**Subject: Eileen O'Connor Catholic School (SSD-67173718) – Environmental Impact Statement**

Thank you for your Major Projects Portal request dated 24 July 2025 seeking advice from the Conservation Programs, Heritage & Regulation Group (CPHR) of the NSW Department of Climate Change, Energy, the Environment and Water (the department) on the Environmental Impact Statement (EIS) for Eileen O'Connor Catholic School (SSD-67173718).

## Attachment 1 - CPHR Assessment Summary for Eileen O’Connor Catholic School Environmental Impact Statement (SSD-67173718)

Flood Hazard Locations along Evacuation Route to Westfield Shopping Centre

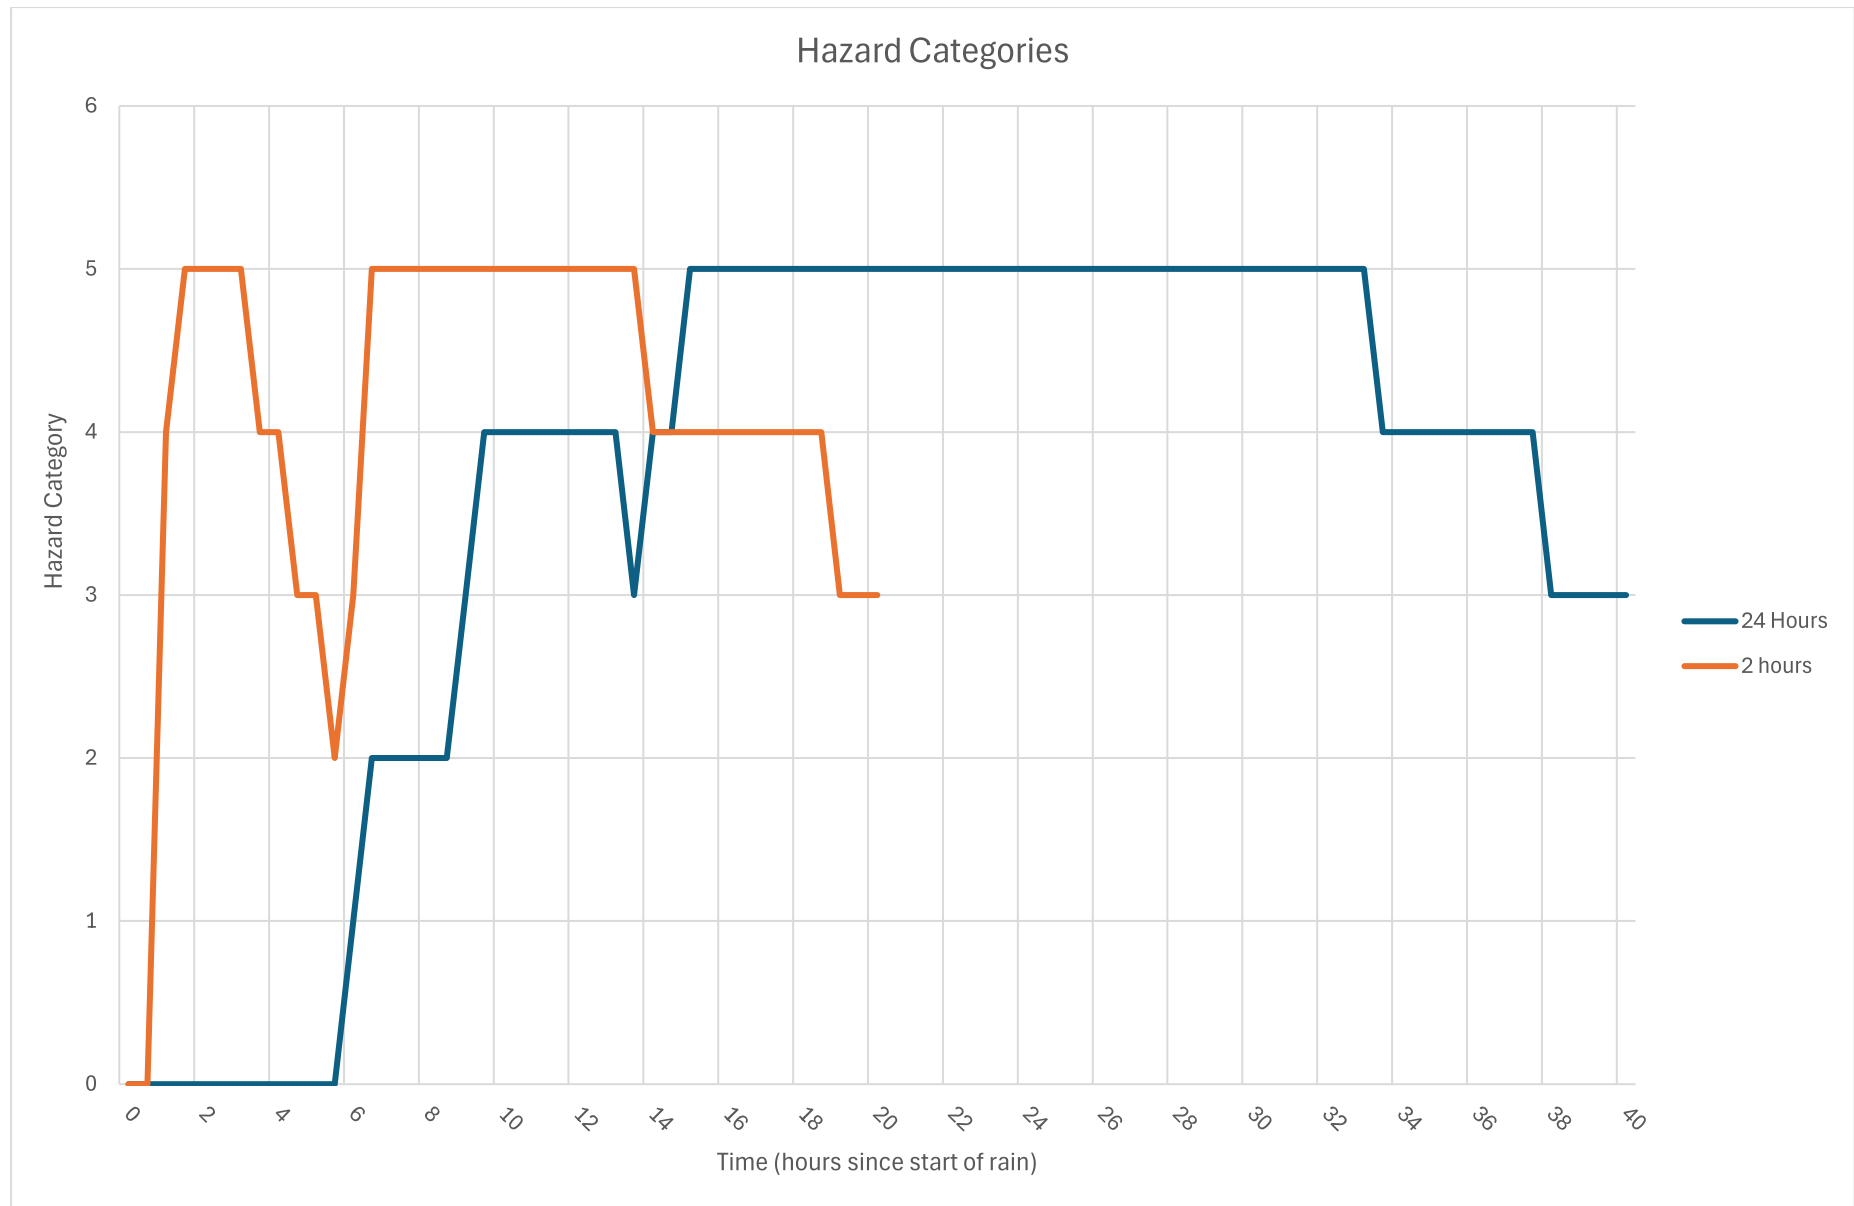
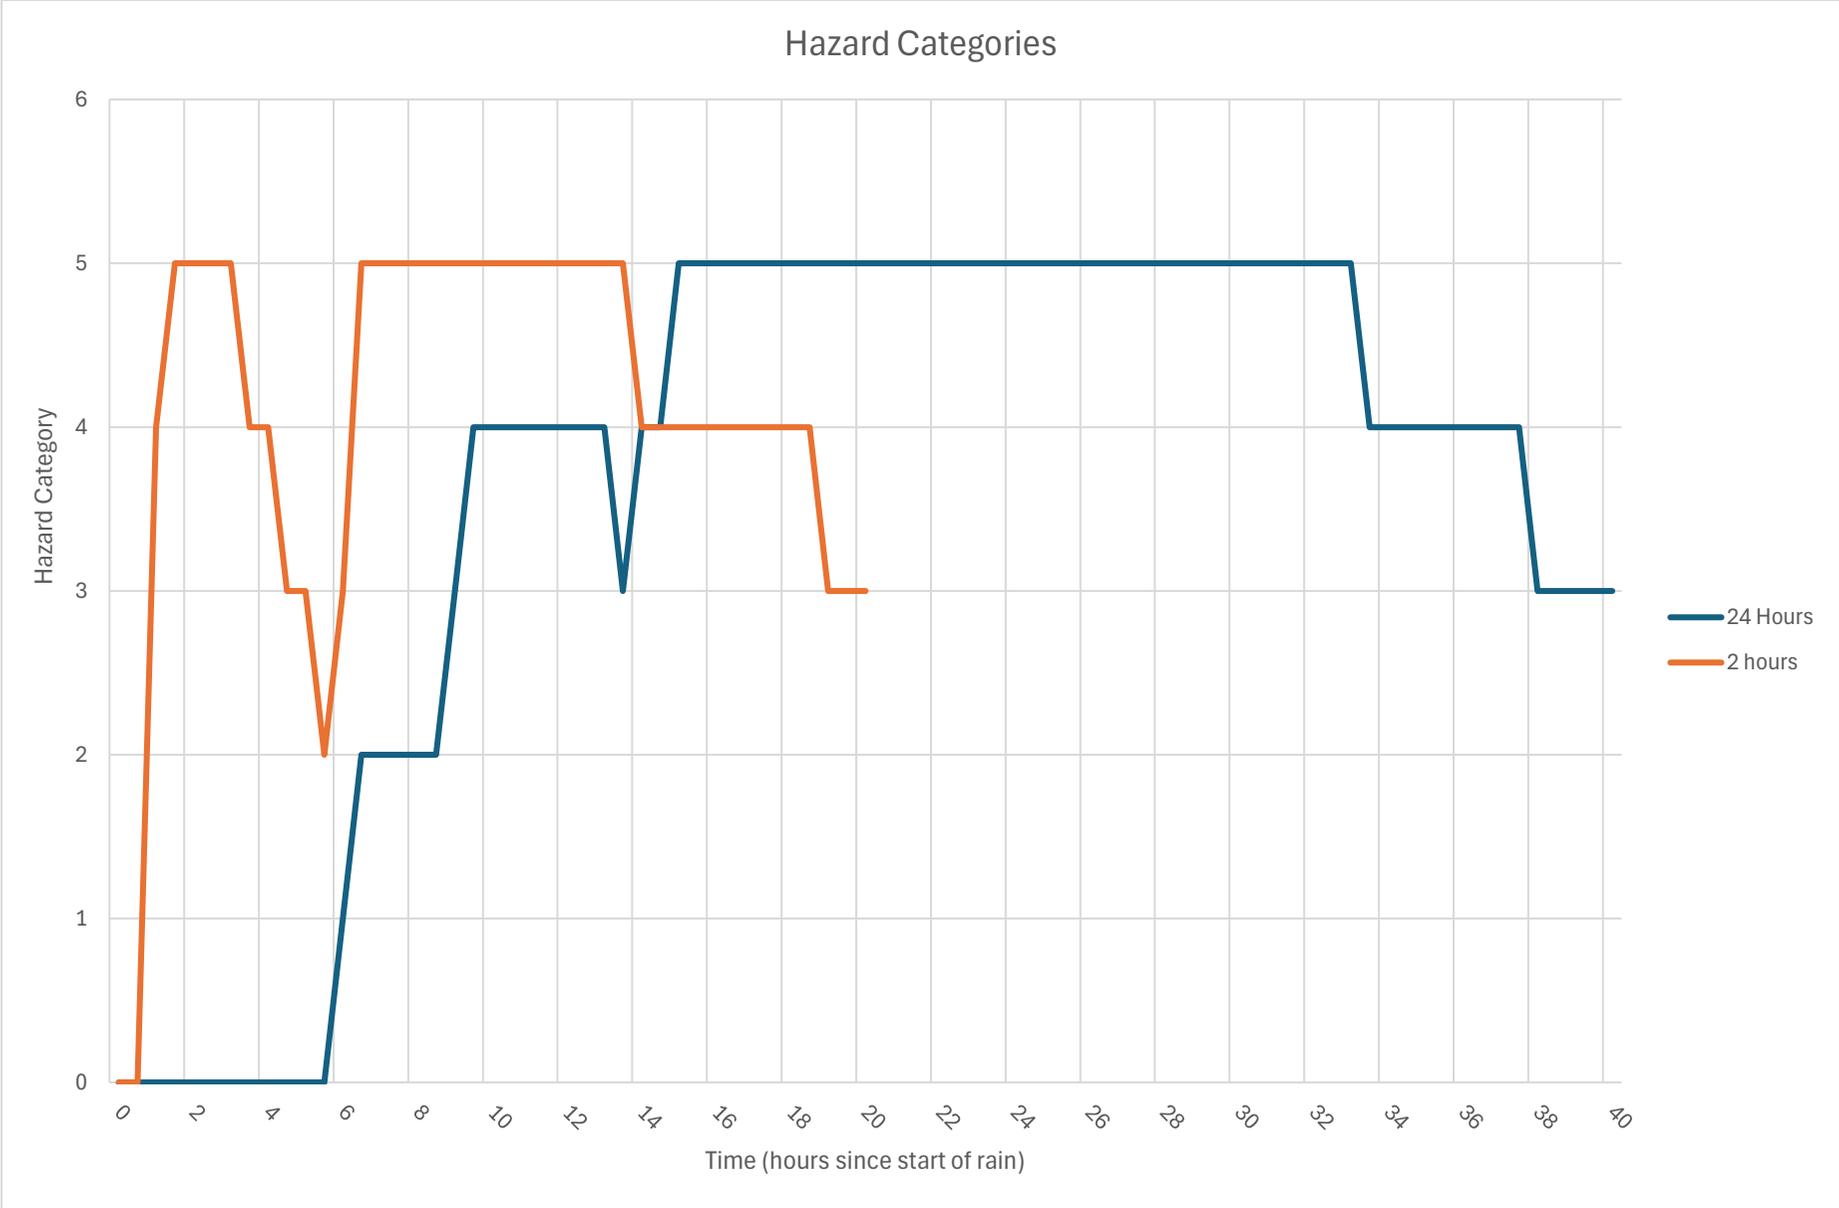
- Adequacy of the proposed off-site refuge:

The FERP proposes Westfield Tuggerah Shopping Centre as a flood refuge. However:

- The centre is not an approved evacuation facility.
- There is no evidence of consultation with the centre management.
- The facility may be unavailable during extreme events due to staffing, infrastructure damage, or utility outages.
- It is unclear whether the centre can accommodate students with special needs.

<i>Recommended action</i>	Engage a suitably qualified flood risk and emergency management consultant to revise the FERP to demonstrate that risk to life can be appropriately managed and so that it includes clear, quantifiable triggers for each emergency management action.
	<i>Extent and Timing</i>	Pre-determination

Flood Emergency Decision Flow Charts

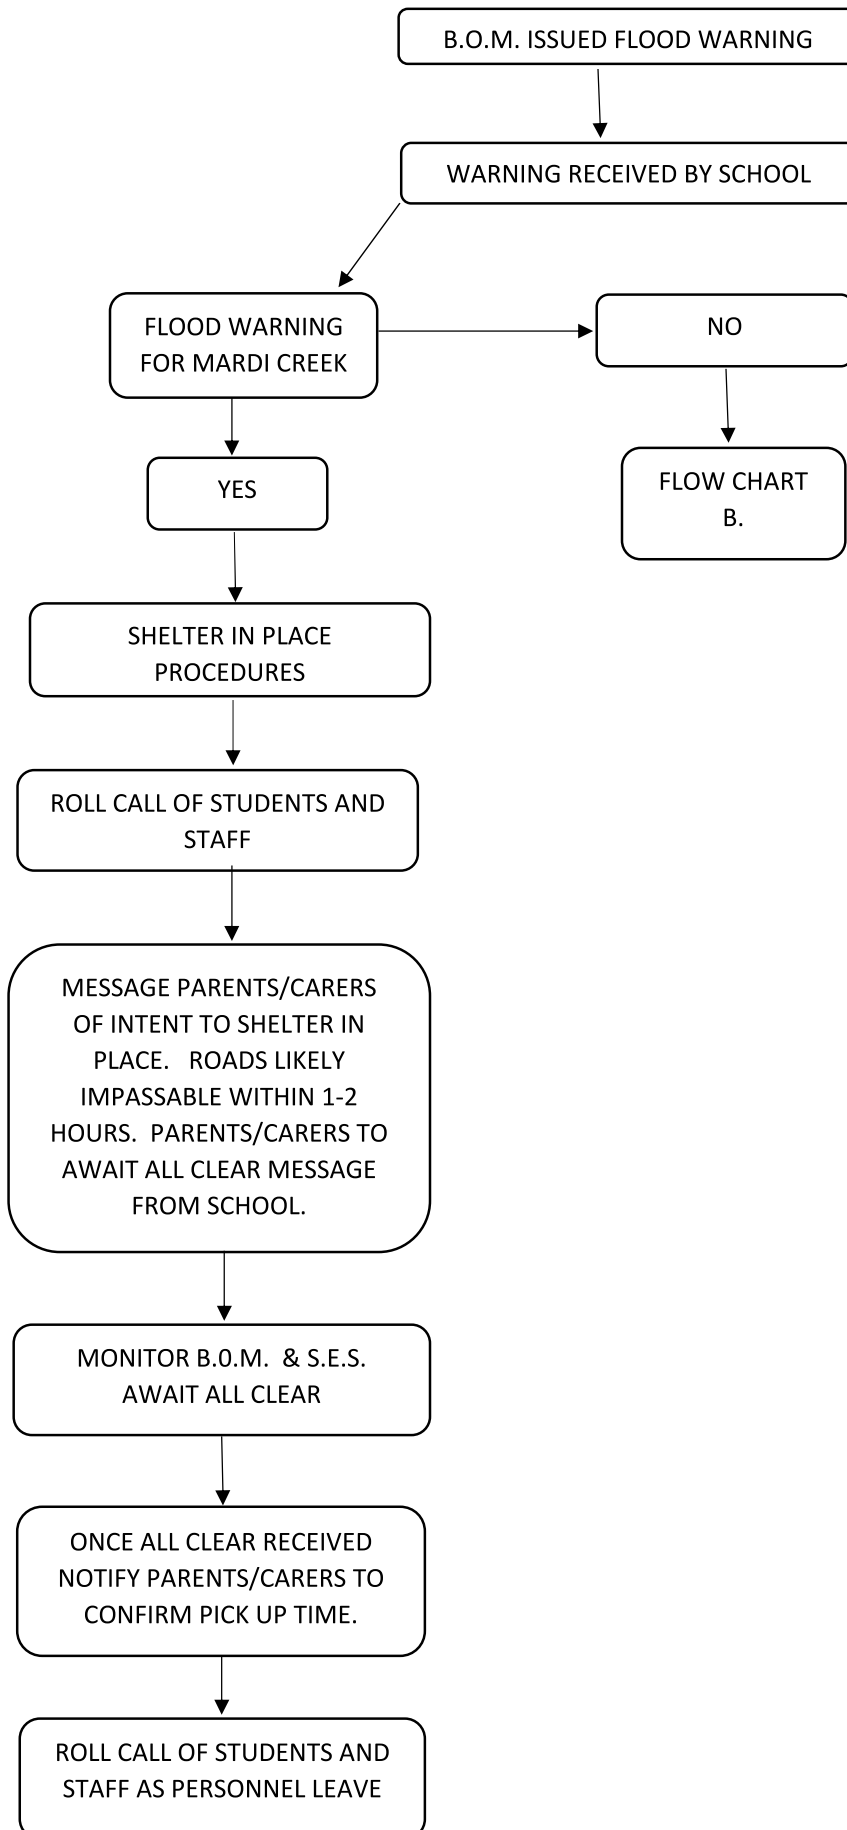
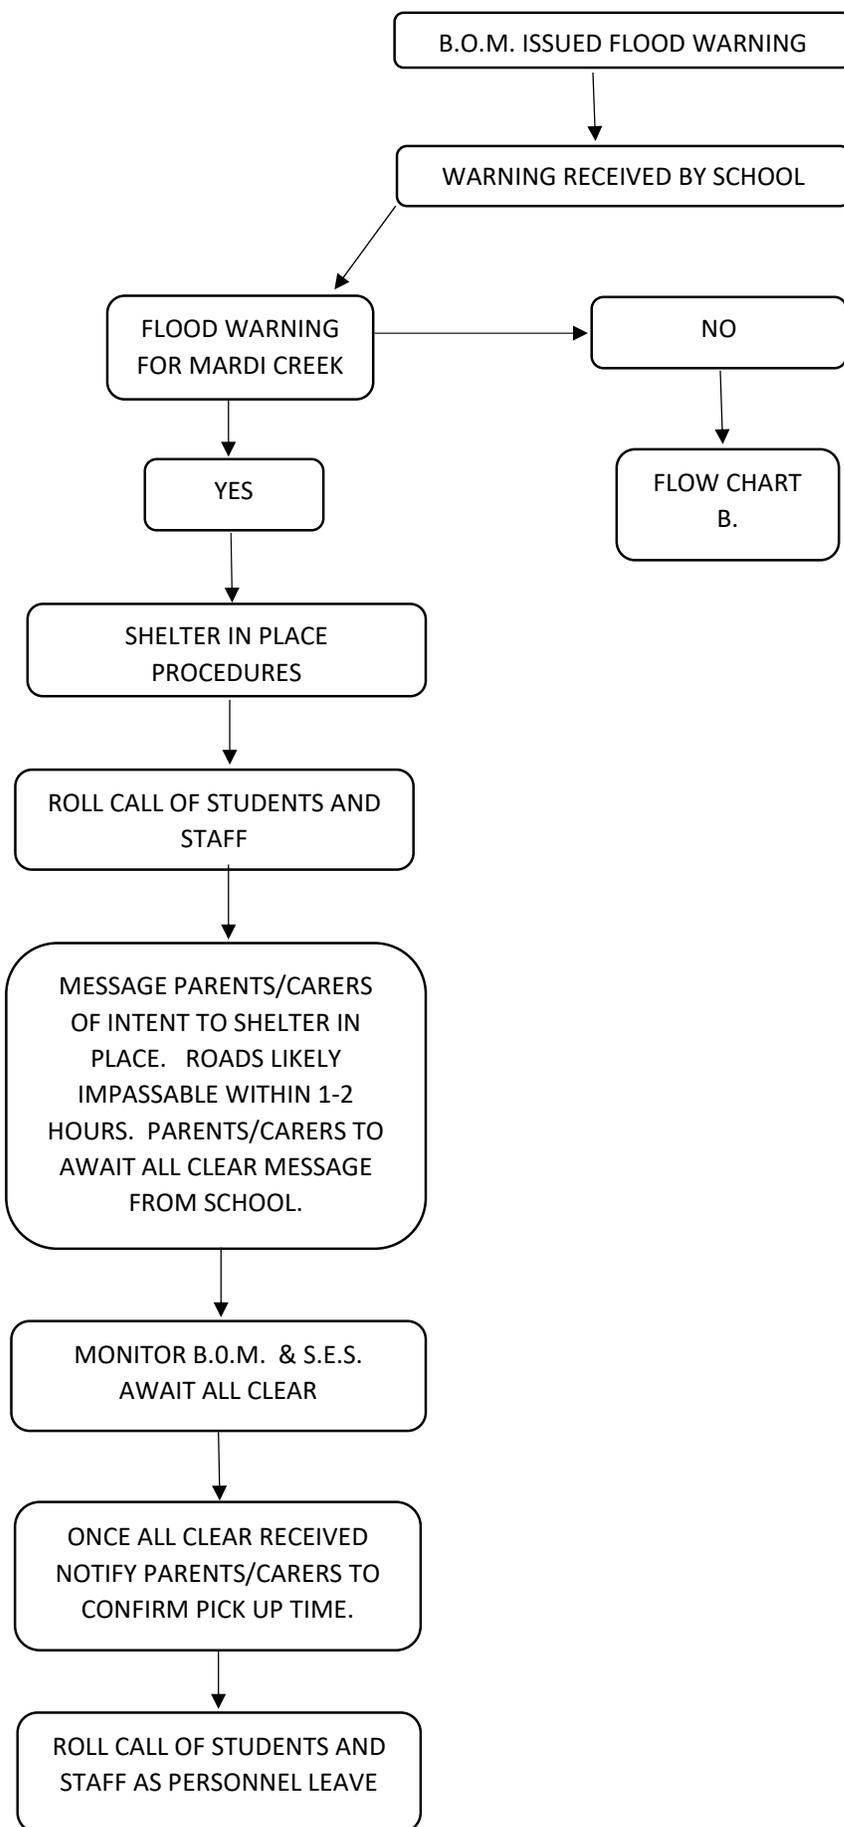
- Ambiguous evacuation triggers that rely on school staff interpreting complex and time-sensitive data. The evacuation triggers outlined in the FERP are unclear and potentially misleading. For example, the statement *“there is at least 2 hours until the water level at the Wyong Bridge begins to rise”* is grammatically incorrect and lacks precision. It is unclear how school staff are expected to interpret or act on this information. Another trigger reads *“if then, the water level at Wyong Bridge has risen to around RL 2.5m in the hour after the BoM warning, then the decision should be to shelter in place.”* This directive is problematic for several reasons:

- It assumes school staff are aware of the exact time the Bureau of Meteorology (BoM) issued the flood warning.
  - It requires real-time monitoring of water levels at Wyong Bridge, which may not be feasible during a rapidly evolving emergency.

- It does not account for revisions to BoM warnings, which could further complicate decision-making.
- No triggers are provided for flash flooding from Mardi Creek.
